Planning Application Ref: M/126/18/T

Location: 46 Silver Birch Drive, Middleton on Sea, PO22 6SJ

Description of works: Prune back branches overhanging property to boundary line, to 1 No Oak tree

**TPO/M1/96
T5**

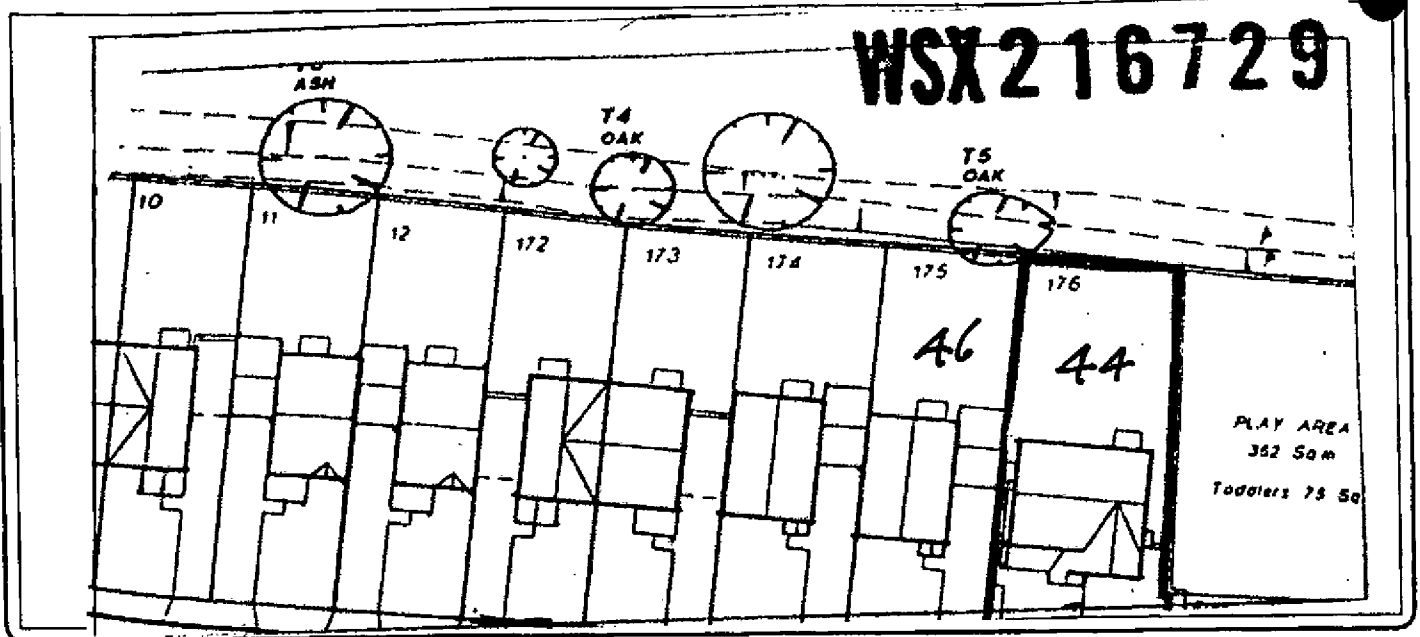
- Outwardly and from a distance it appears to be in a fine physiological state with a relatively unmodified and attractive crown profile.
- It grows at the rear of the property in public parkland/open space and is a long-established boundary feature. It can be seen from neighbouring dwellings and publicly accessible land.
- The applicant proposes the reduction of branches back to the property boundary line.
- There is a singular, prominent low limb growing directly into the garden and over the shed. It has a number of suitable branch junctions back to which it could be successfully pruned and achieve adequate clearance.

- The work proposal as described is unnecessarily severe and would result in relatively large wound sizes, exceeding the requirements of British Standard 3998:2010 Tree Work – Recommendations.
- The intention is reasonable and some work would be acceptable, where it seeks to maintain reasonable enjoyment of the garden with respect to natural tree form.

- I would like to see the applicant submit a revised specification seeking lesser work, such as detailed below, which would seem to address their concerns whilst fully respecting the ongoing health and vitality of the tree:
 - Reduce length of prominent low limb by no more than 2.5m, positioning final cut at strong branch junctions, leaving a wound no greater than 60mm diameter.
